Arun District Council
Arun Civic Centre
Maltravers Road
Littlehampton
West Sussex BN17 5LF
Planning & Building Control General Enquiries
Tel: (01903) 737756 Fax: (01903) 730442
Dx: 57406 Littlehampton
Minicom: 01903 732765
e-mail: planning@arun.gov.uk
website: www.arun.gov.uk/planning

Application No: AL/87/21/PL

Site Address: Oldlands Farm Newlands Road Bognor Regis PO22 9FJ

Thank you for your internet representation made on 25th July 2021 which has been recorded as no objection with the comments as follows:

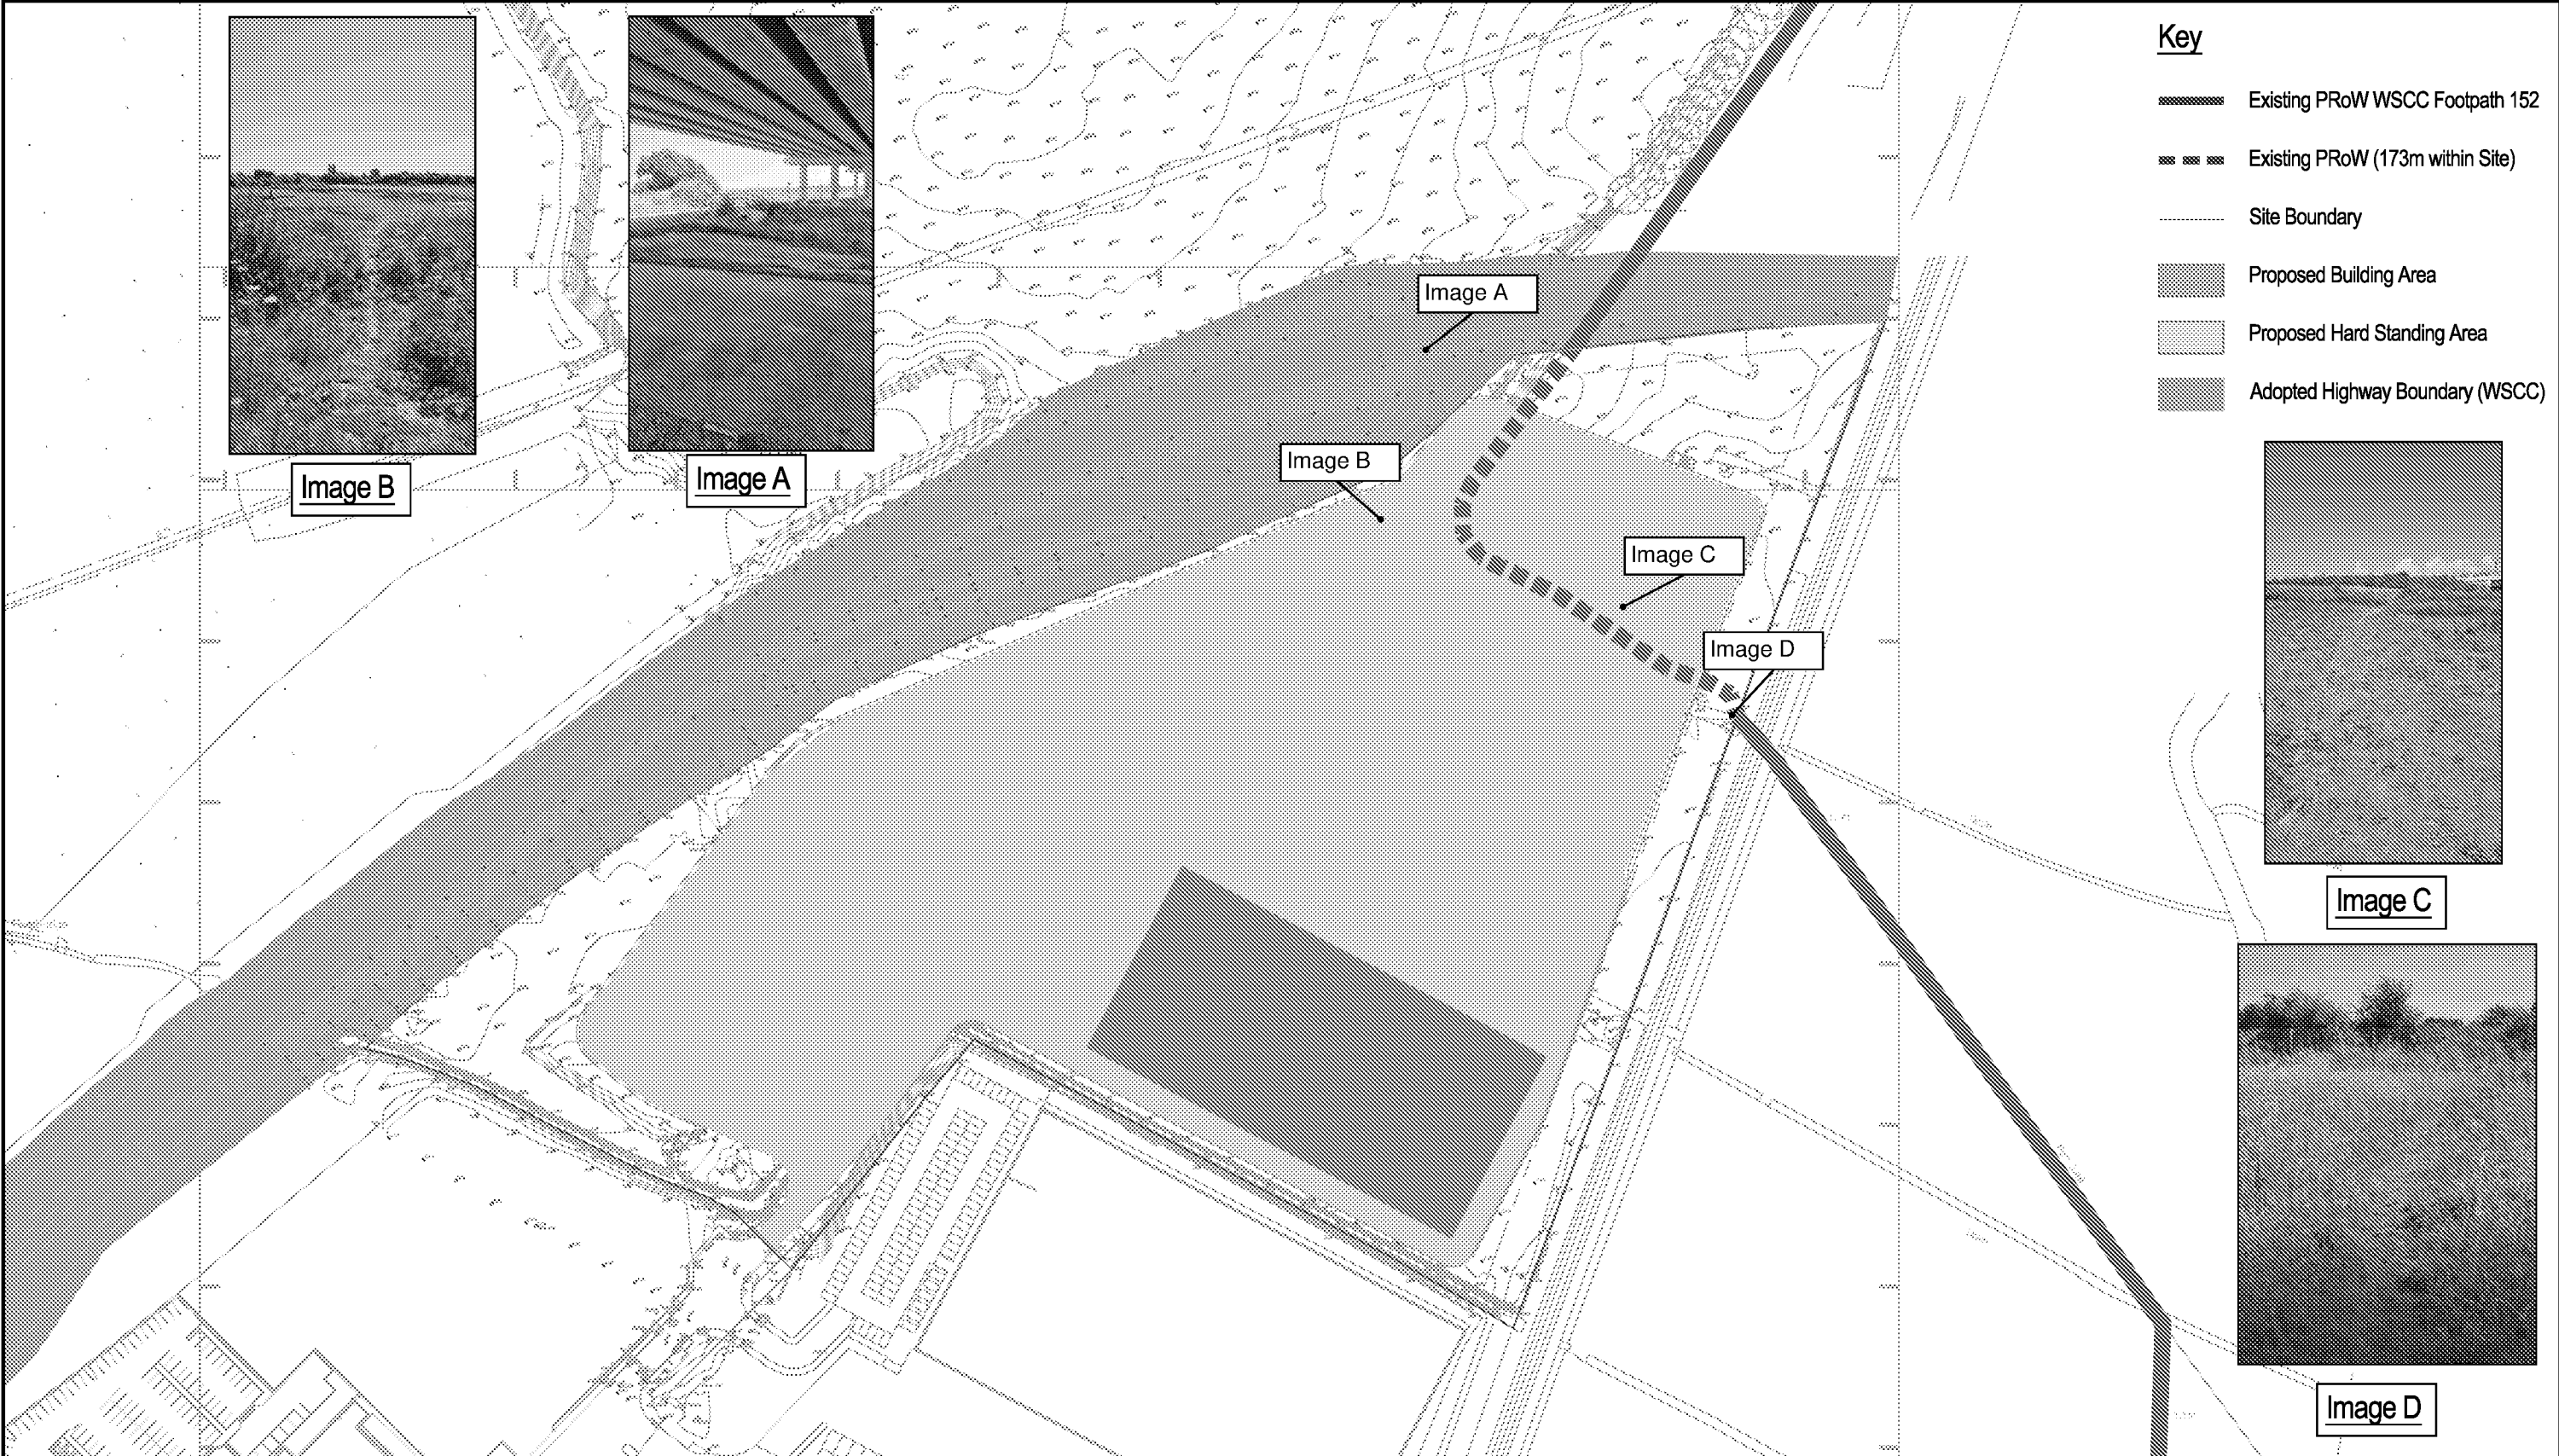
- The redirection of the PRoW (if approval is granted) should be prioritised to ensure the continuity and

enhancement of local rights of way.
